CITY OF ALBUQUERQUE

March 4, 2015

RE: **Applebee's
Grading Plan
Engineer's Stamp Date 2-27-2015 (File: K09-D038)**

Based upon the information provided in your submittal received 2-27-15, the above referenced Grading Plan cannot be approved until the following comments are addressed:

drawing number  
C2

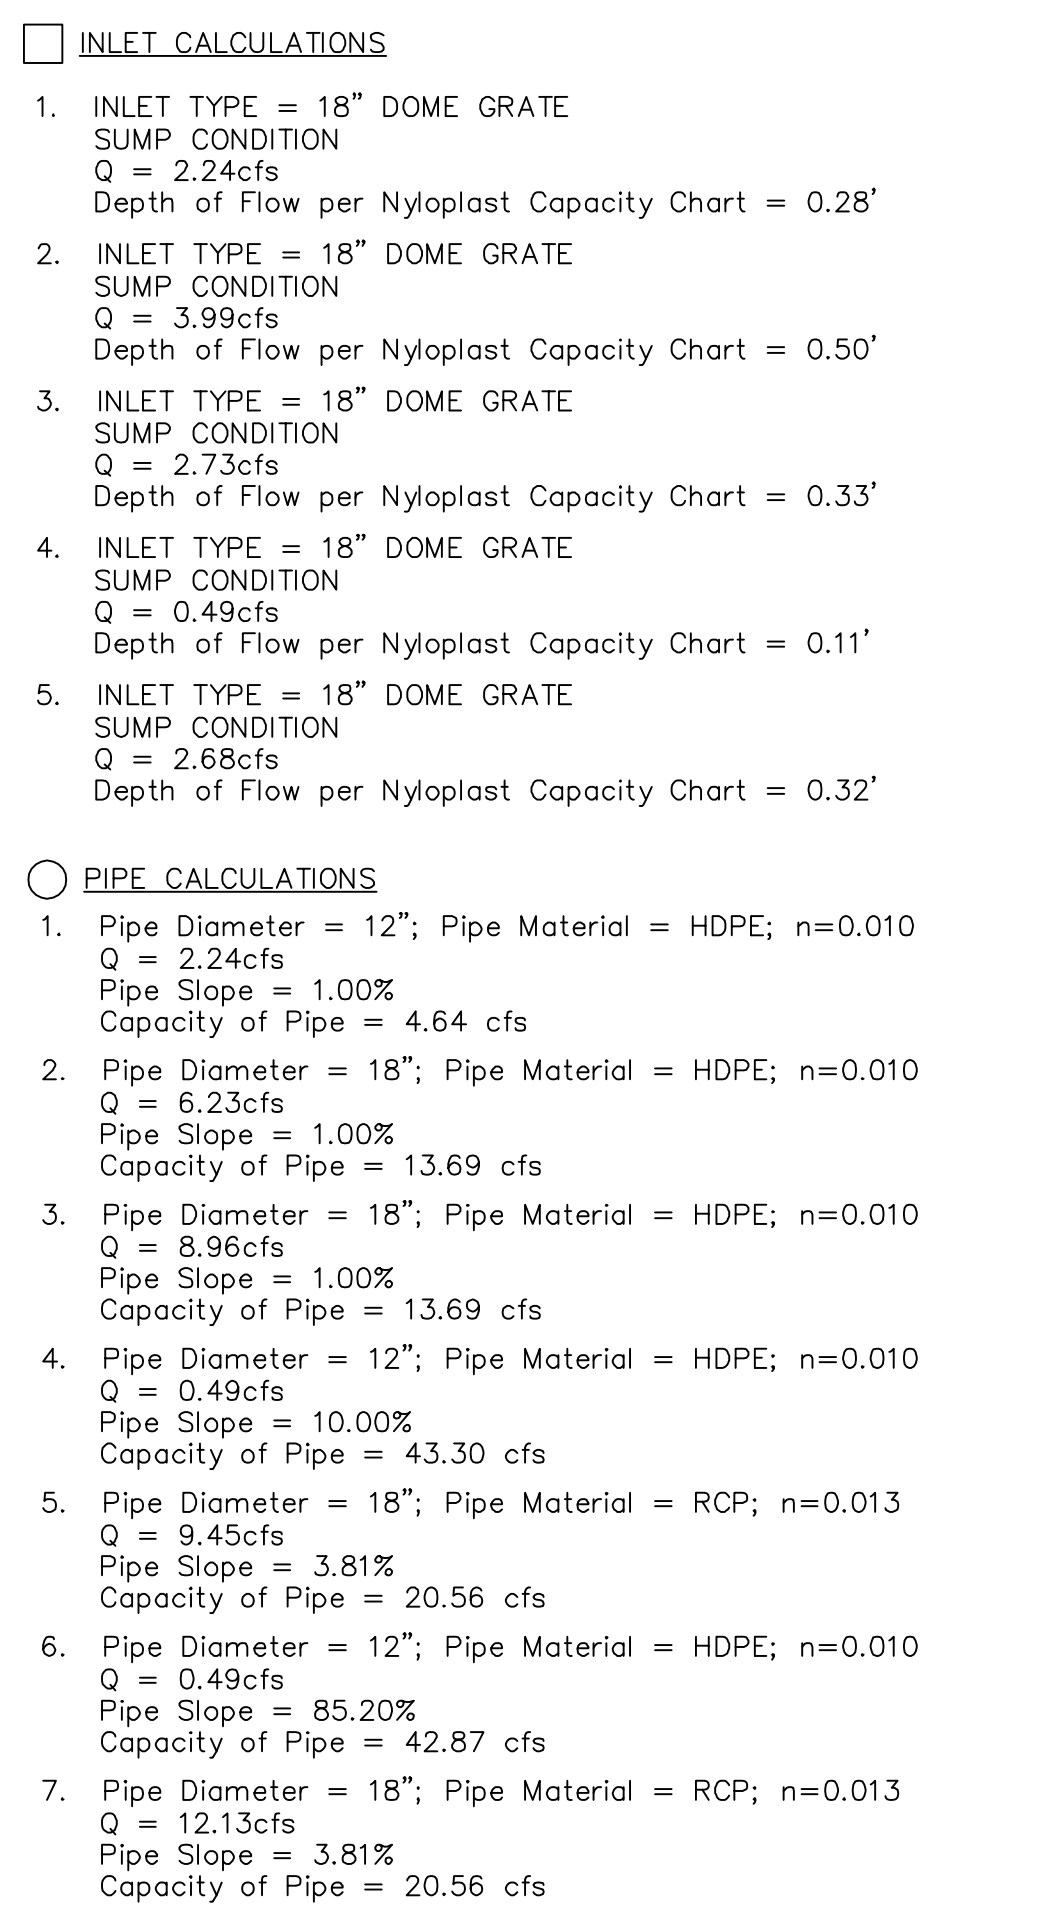
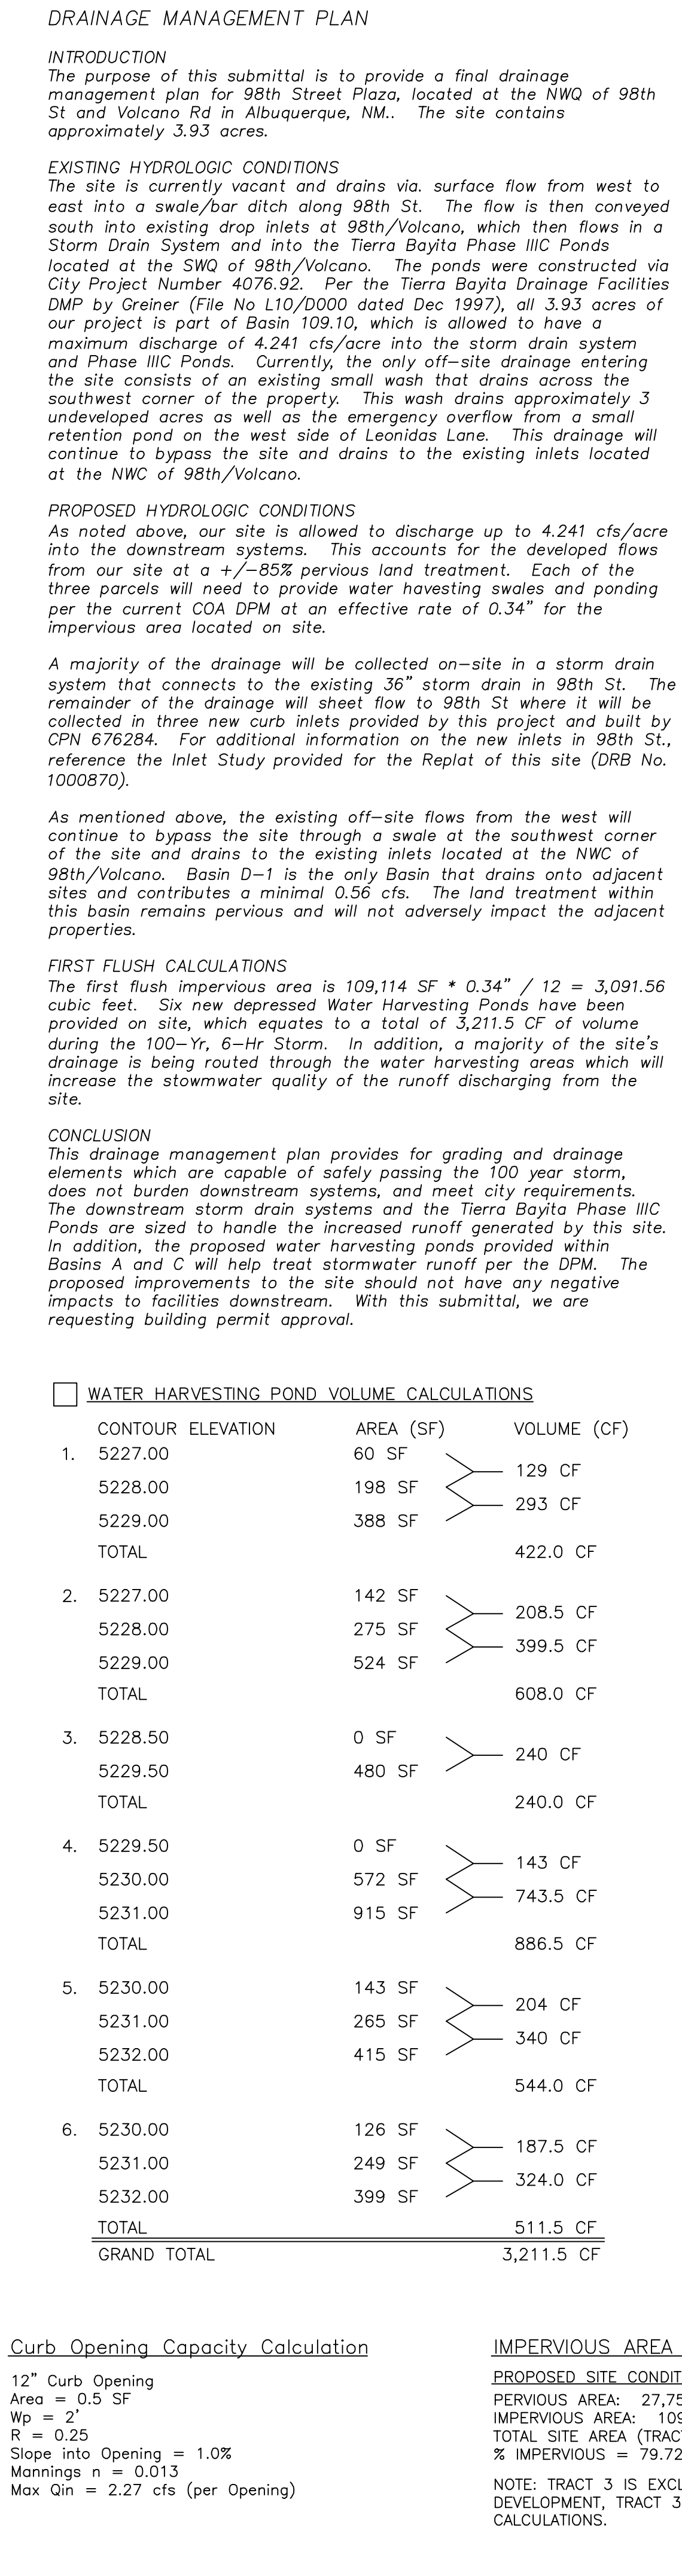
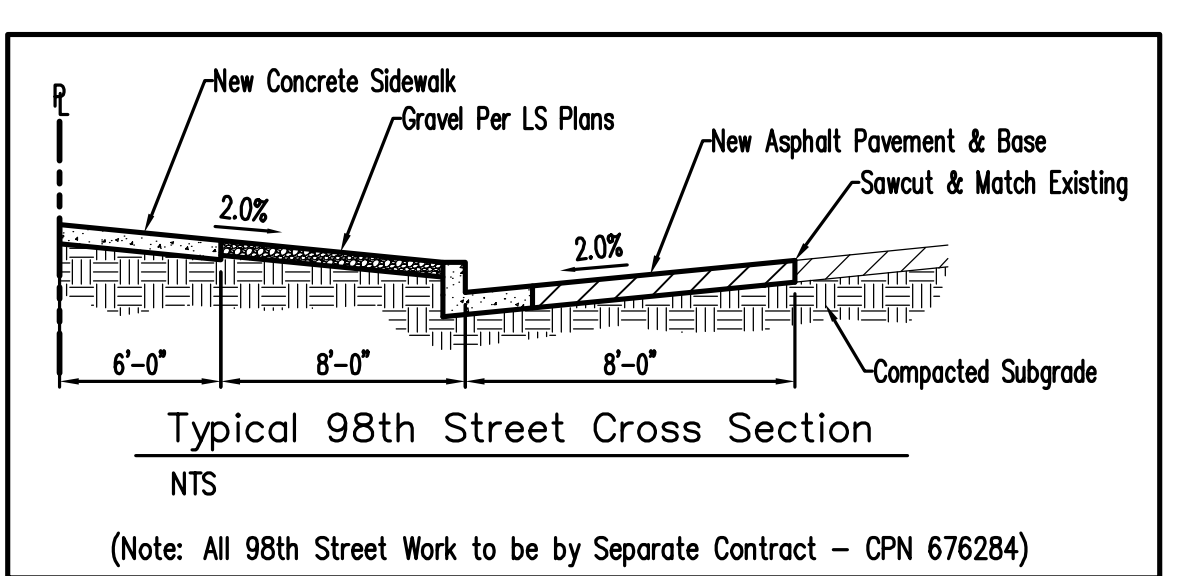
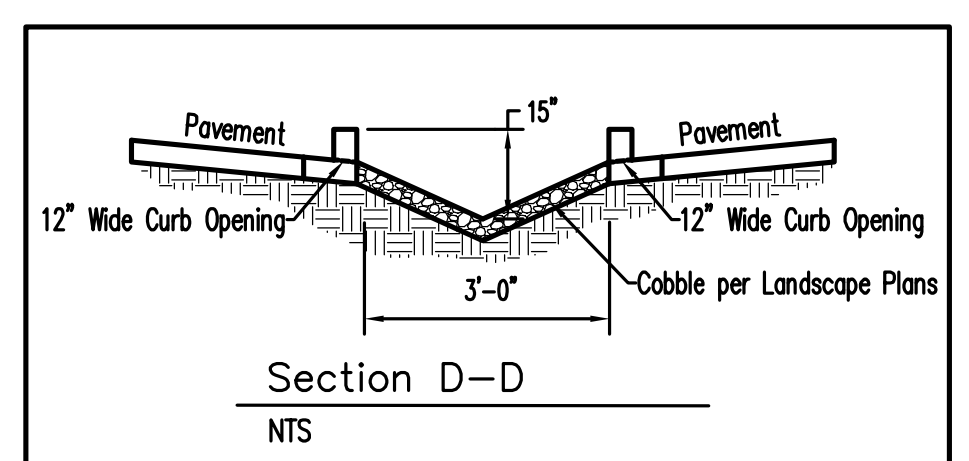
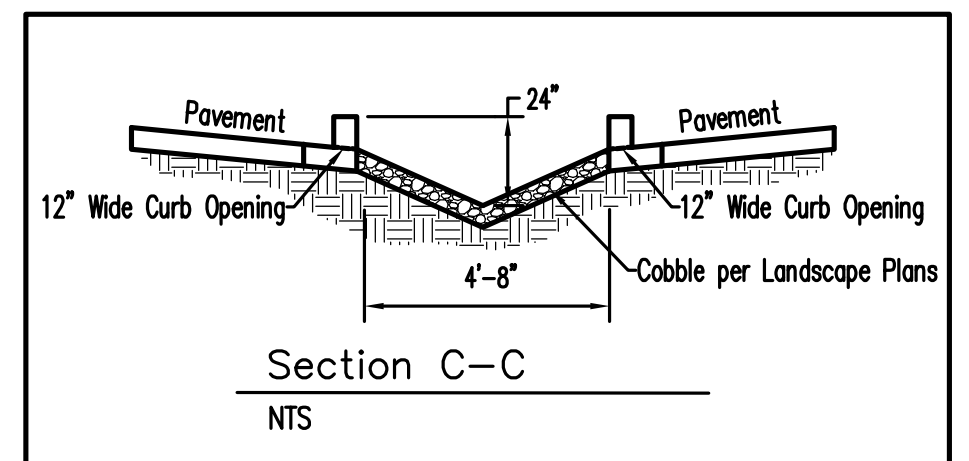
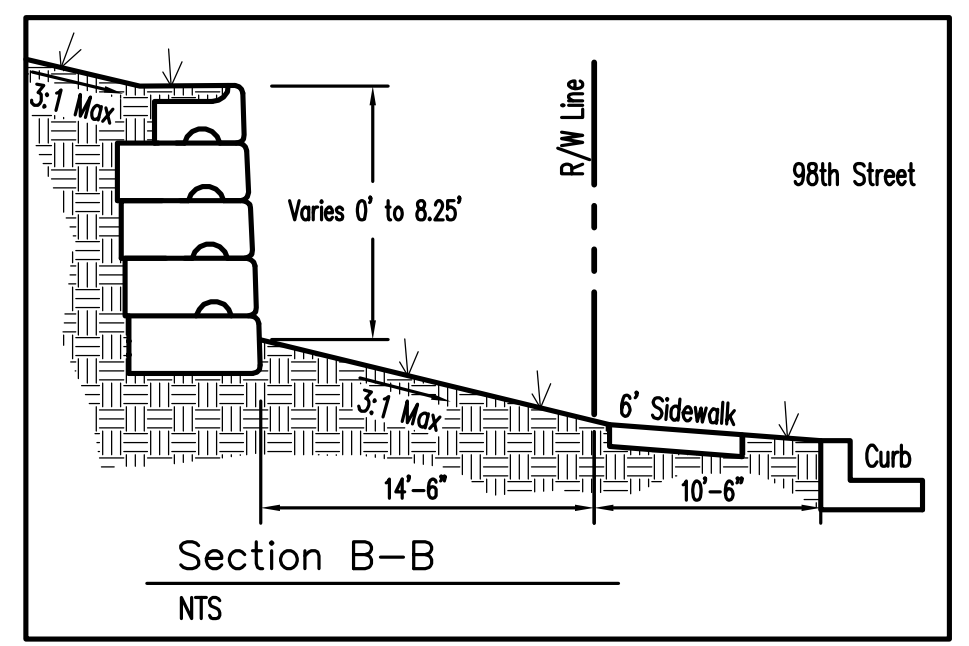
- 1) For 98th Street, label curb and gutter flowline and top of curb elevations. Label sidewalk elevations to show that the subject site is draining to the street. Also, show and label all proposed inlets on the grading plan along with grate elevations.

- 2) On the Grading Plan, for the on-site drainage system, label the flow that each of the pipe runs is conveying. Provide capacity calculations for both the on-site storm drainage pipes and the inlets.

- 4) The curb cuts need to be shown in the low spots for the water harvesting areas in between the parking spaces. It makes more sense to have curb cuts where FL Elevation 29.00 is shown for the island instead of upstream close to where Section D-D is shown. Provide capacity calculations for the curb cuts. (You have called out more curb cuts on the Traffic Circulation Plan, but all of these curb cuts need to be called out on the Grading Plan since they influence drainage.)

- 5) All water harvesting area should be labeled as such, and conceptual flow arrows and spot elevations should support the concept. Include discussion of the various individual water harvesting areas in the report write-up. Why is over 15,000 square feet cubic feet of volume being provided if only 3,091 cubic feet is required? Also, due to the amount of impervious area for the Applebee's building alone, provide a water harvesting area north of this building.

6) An elevation of 29.50 is provided next to the inlet on the southwest corner of the site which is lower than the inlet grate. Is this a water harvesting area? If so, label it as such.

7) Show proposed pad height for future building on Tract 3.

drawing title  
Site Details  
drawing number

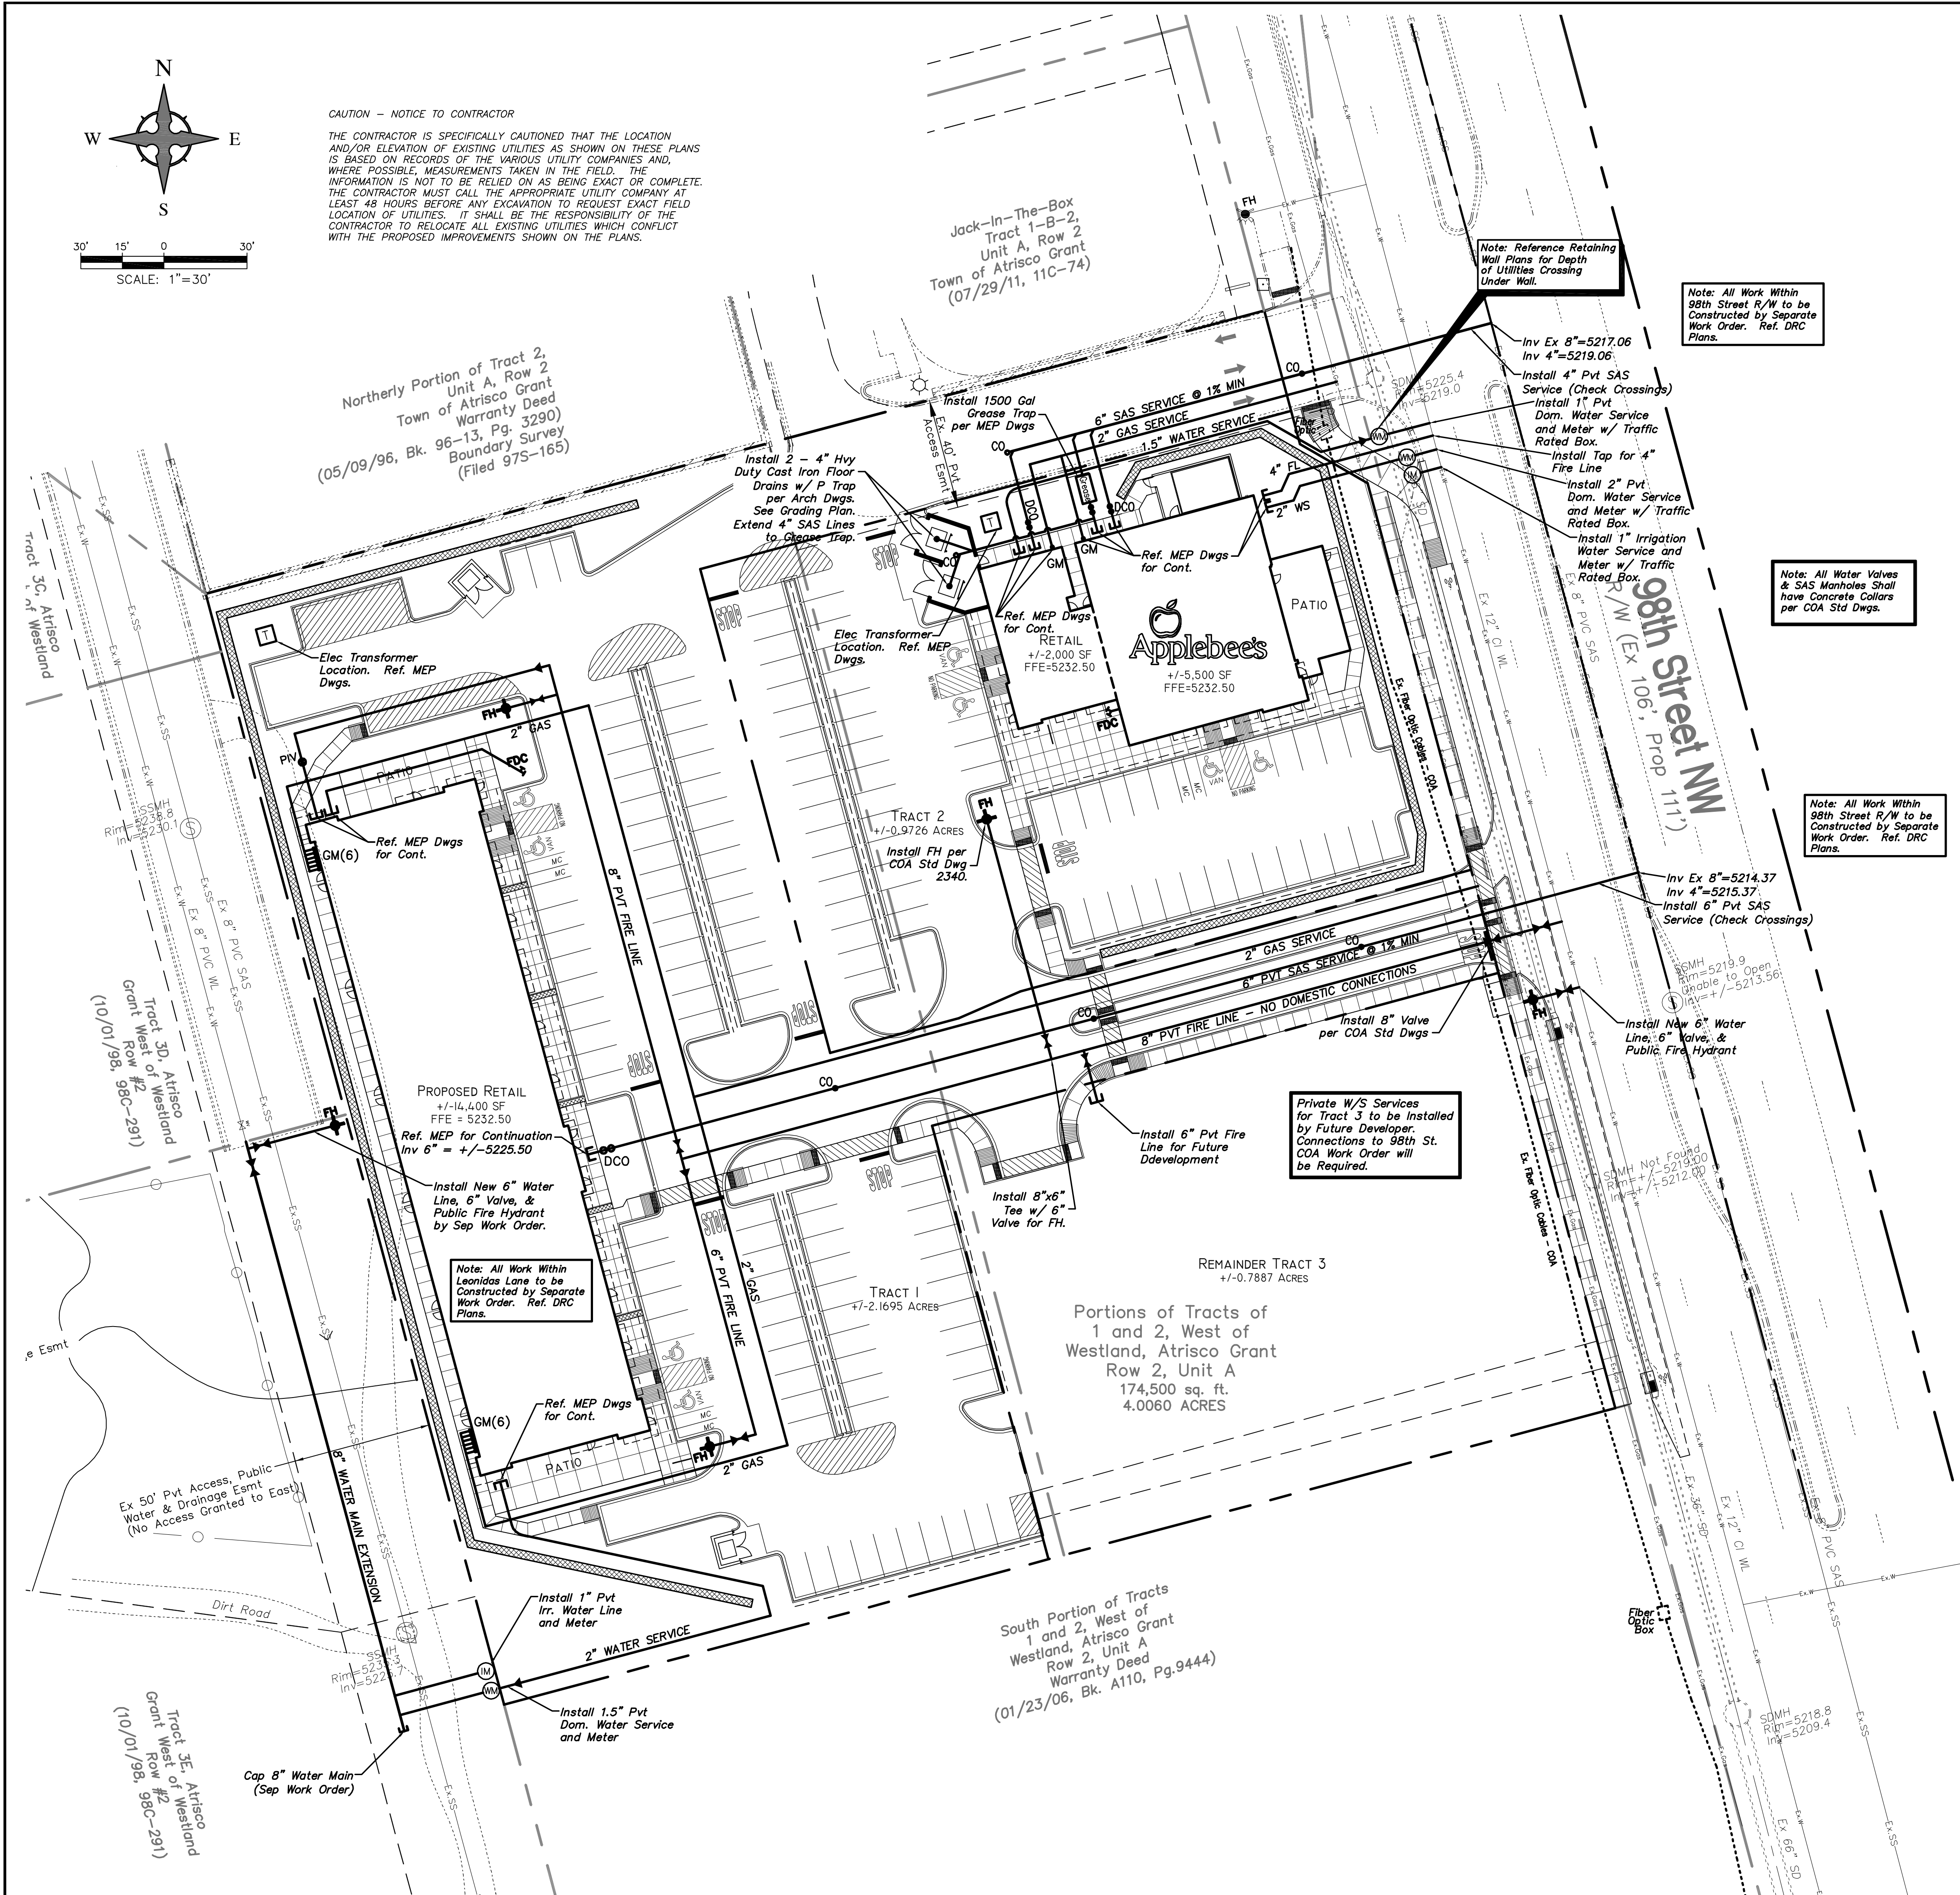
8) As per the DPM for restaurants, it is required to have a grease trap that discharges to the sanitary sewerline. (This will be required for the dumpsters for Applebee's.)
